**Consultation Response from KC,  
Trees**

**2026/90594 11 , Wood Street, Skelmanthorpe, Huddersfield, HD8 9BN**

**Discharge of condition 11 (arboriculture method statement) on previous permission 2024/91934  
for demolition of existing dwelling and erection of four dwellings**

**Date Responded: 02/07/2026**

Drawing Title:
Tree Protection Plan

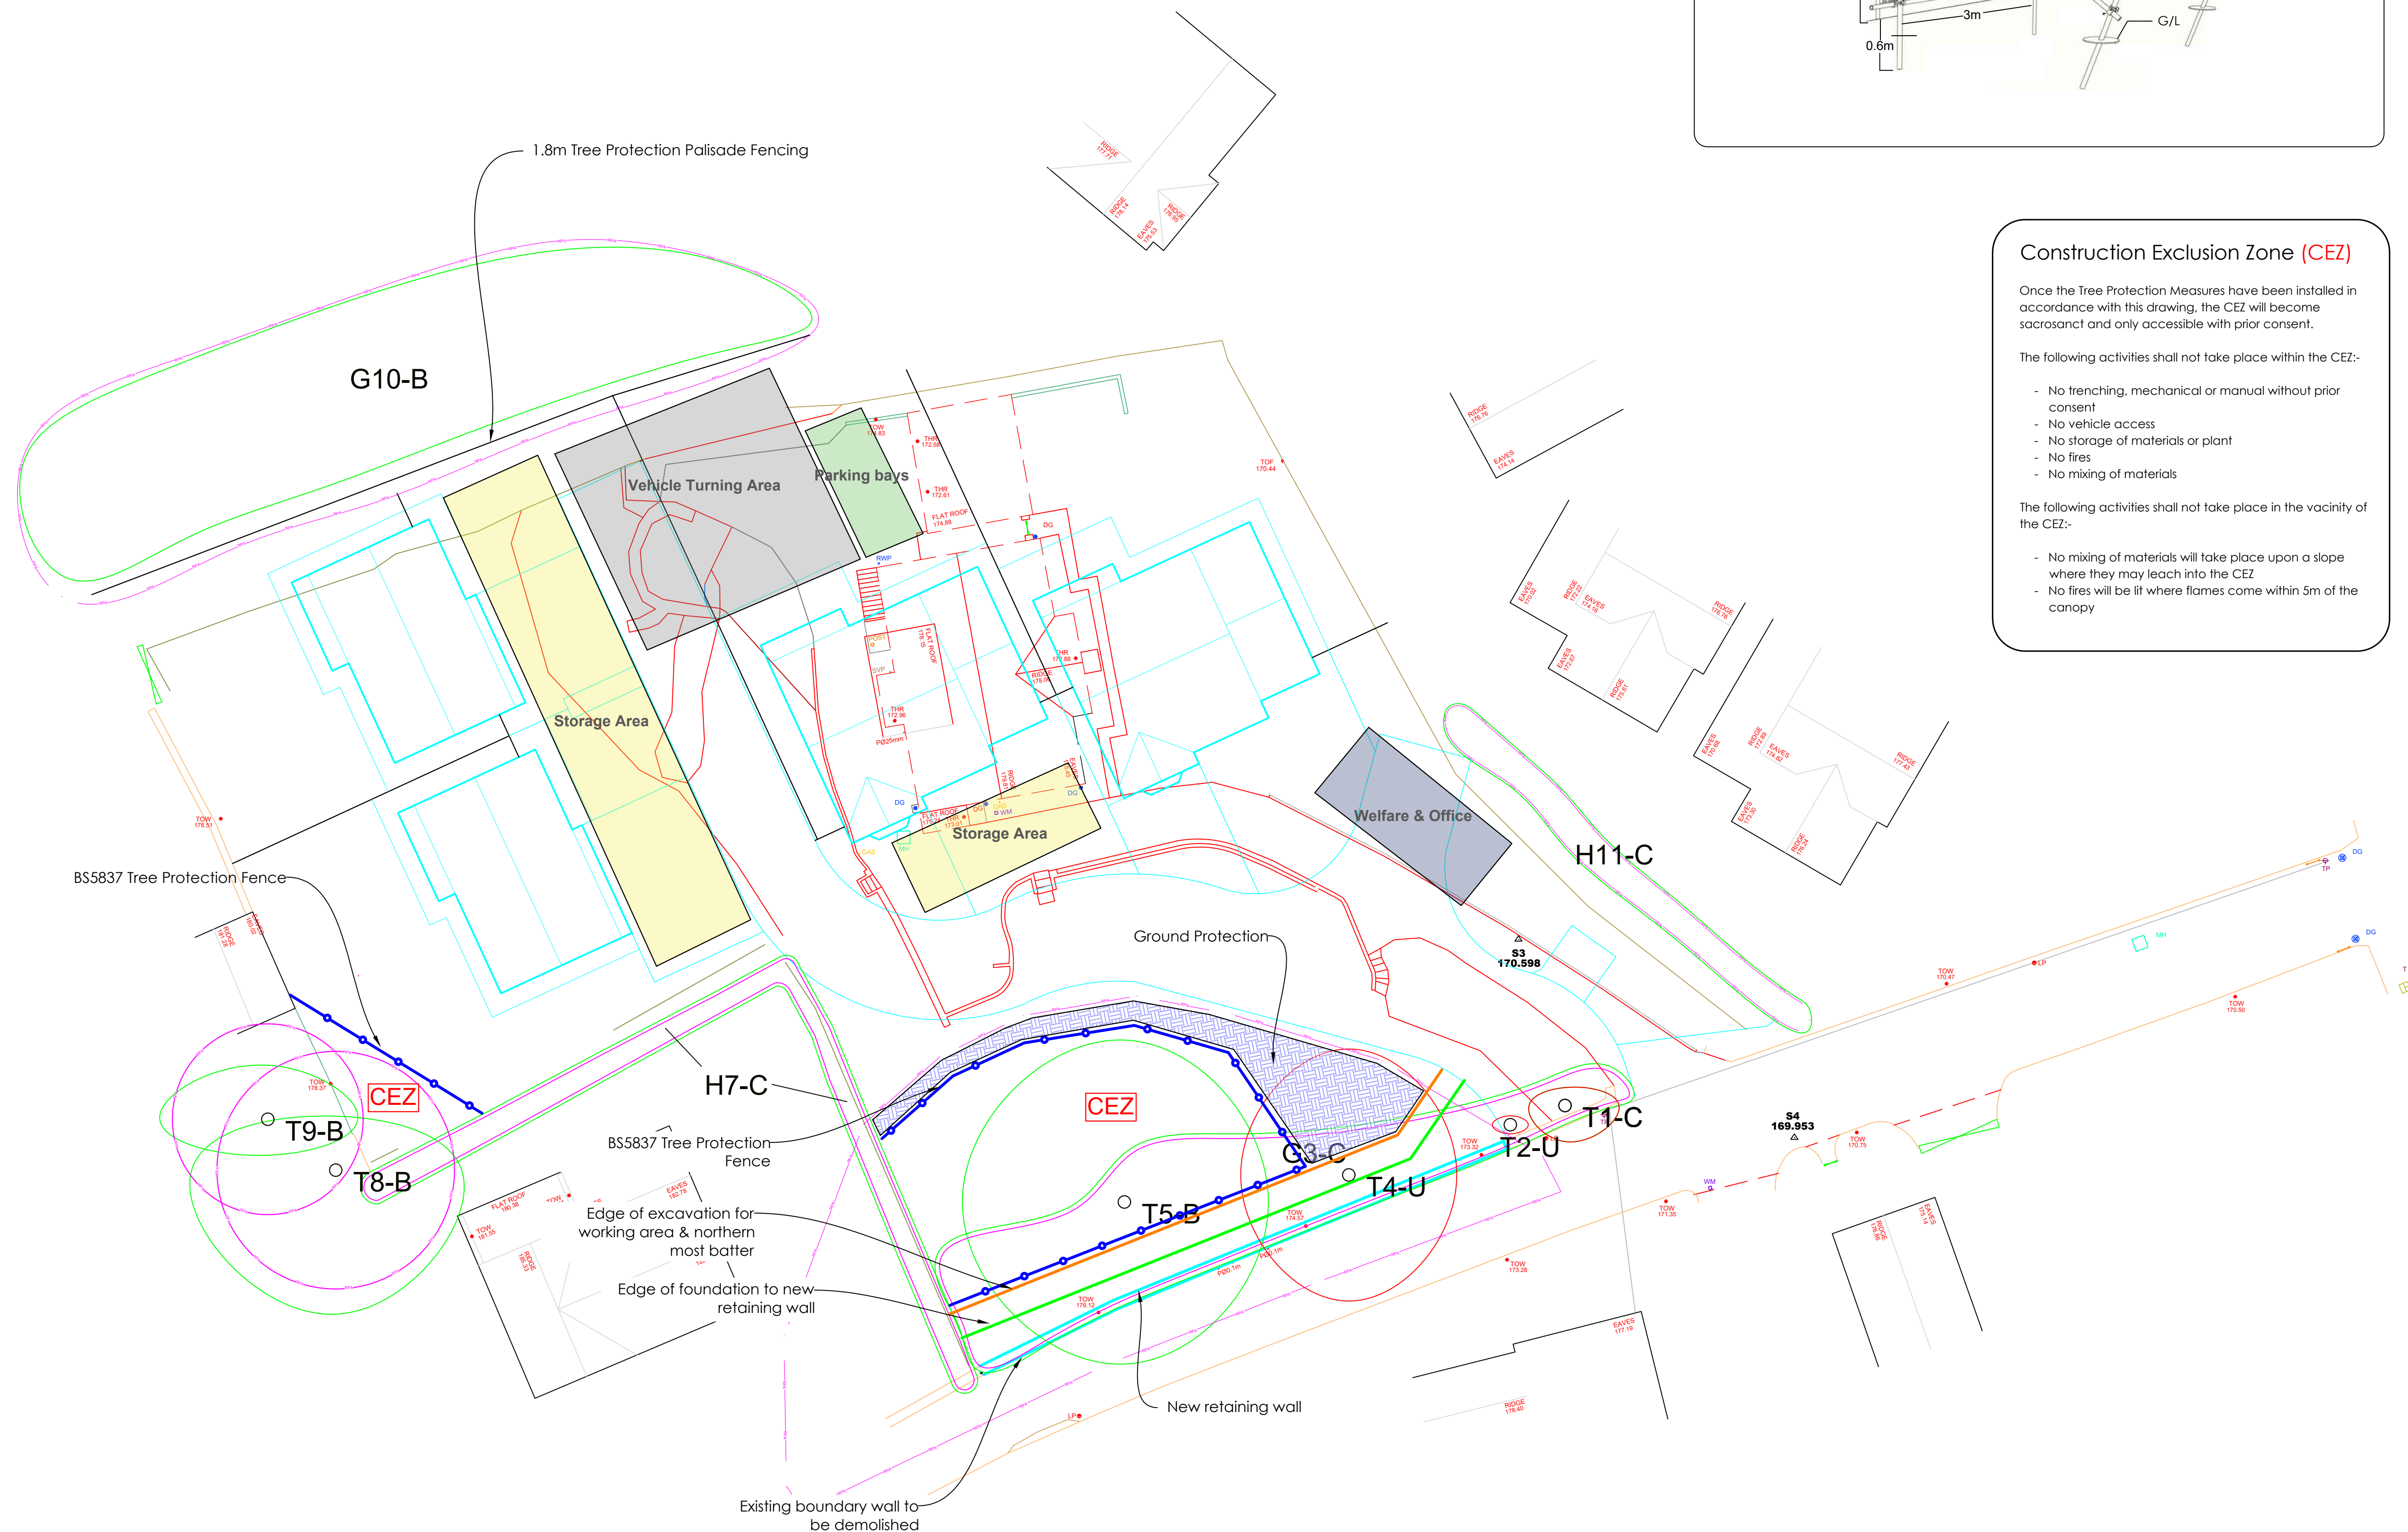
**The AMS does not satisfy Condition 11 as it does not demonstrate how protected tree T5 (TPO ref. 03/22/t1) can be safely retained through the proposed development.**

The full extent of the RPA must be enclosed with the Construction Exclusion Fencing where possible. This has also been previously communicated with the project arboriculturalist. We cannot accept the lesser protection as suggested within the AMS. Given that there would be damage to the roots of T5 along the area of the retaining wall, I see no justifiable reason why it should be acceptable for the development to risk any further disturbance to the rooting area.

Appendices D - Typical Section Through Retaining Wall Works.

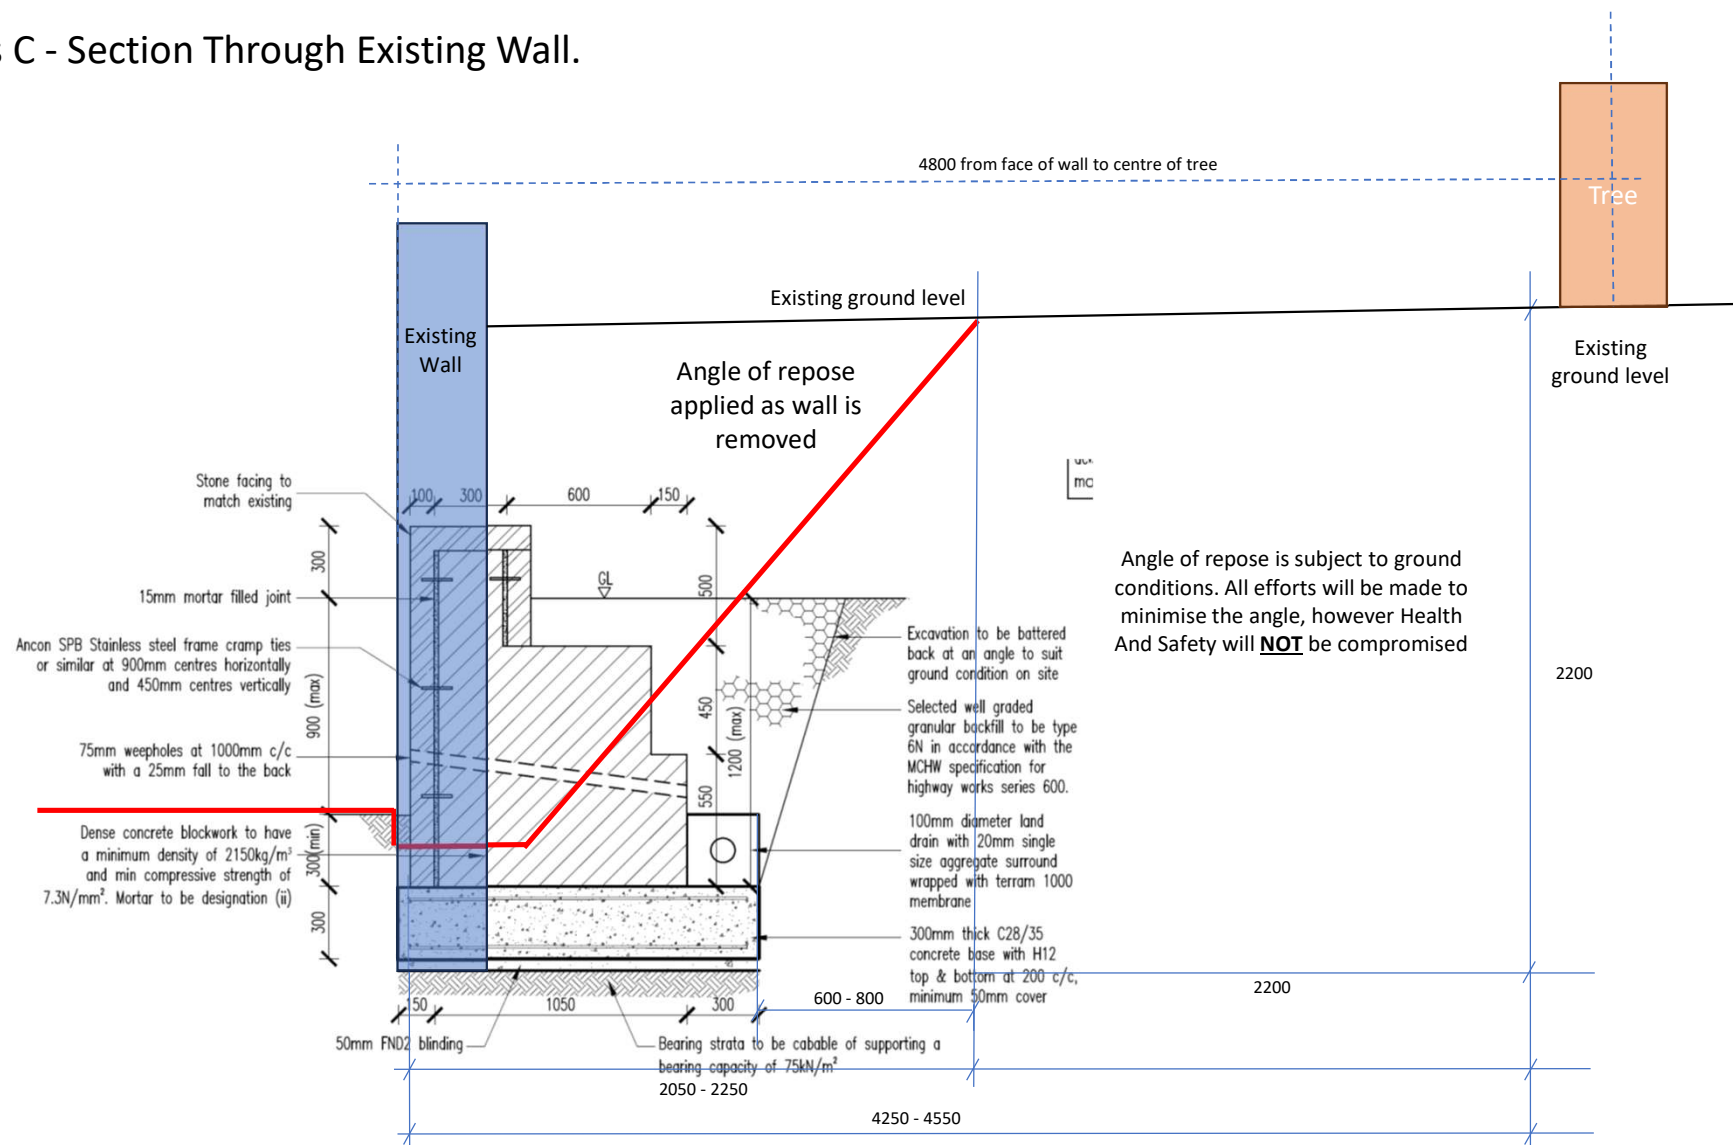
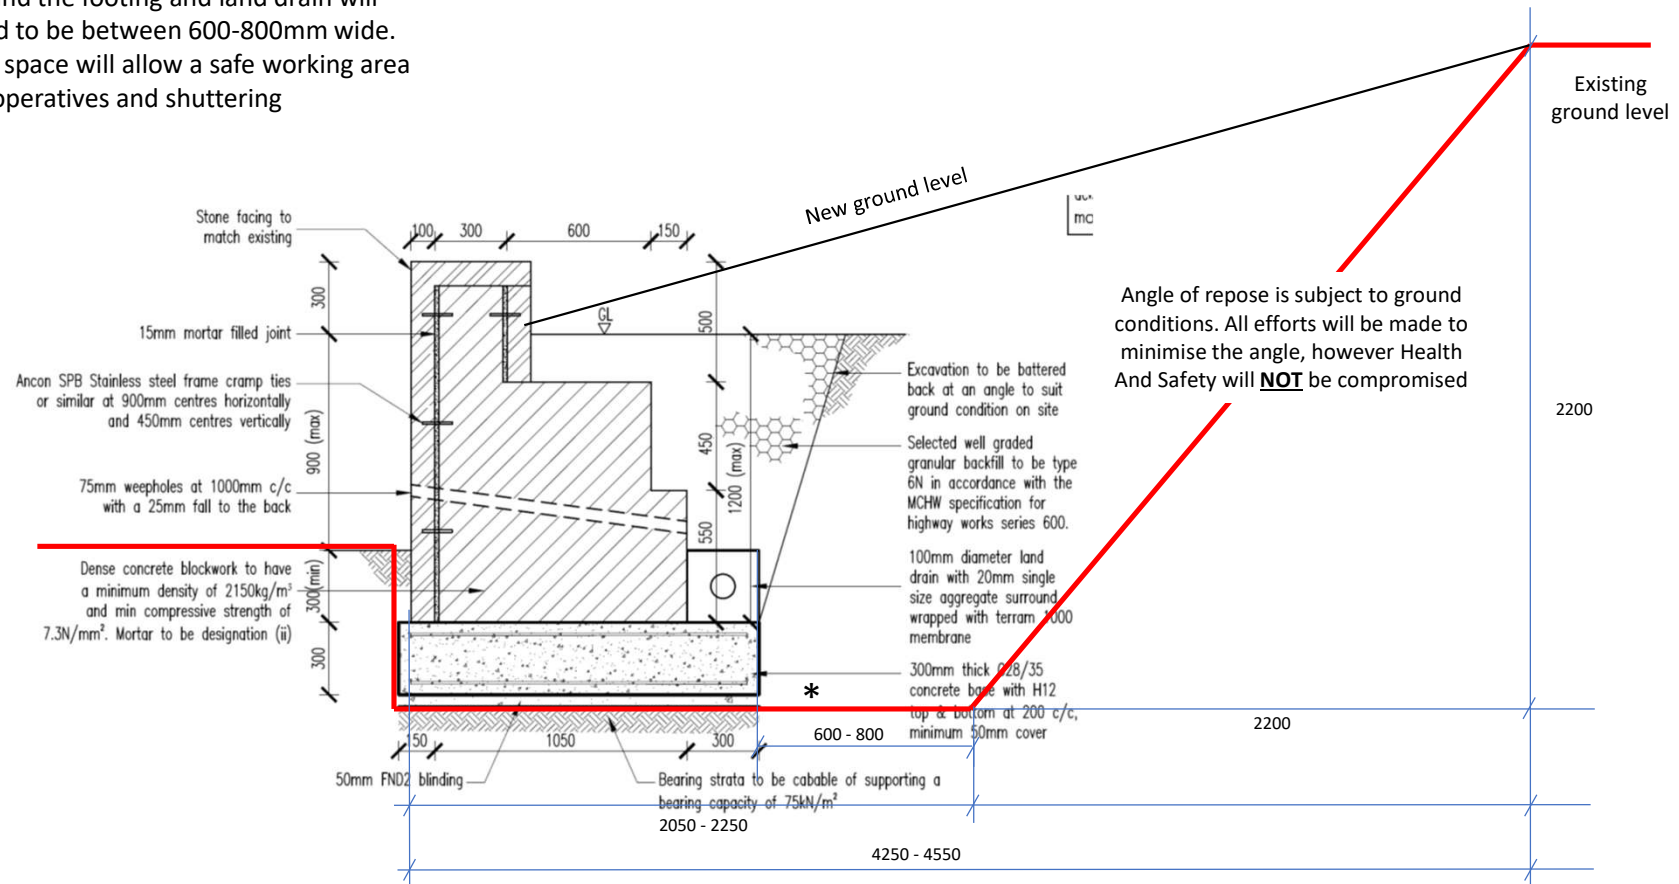
The extent of the proposed excavation for the working area and batter would threaten the health of the protected tree and potentially cause it to become unstable and dangerous over the highway. This was previously discussed on site with the project manager, arboriculturalist and engineer.
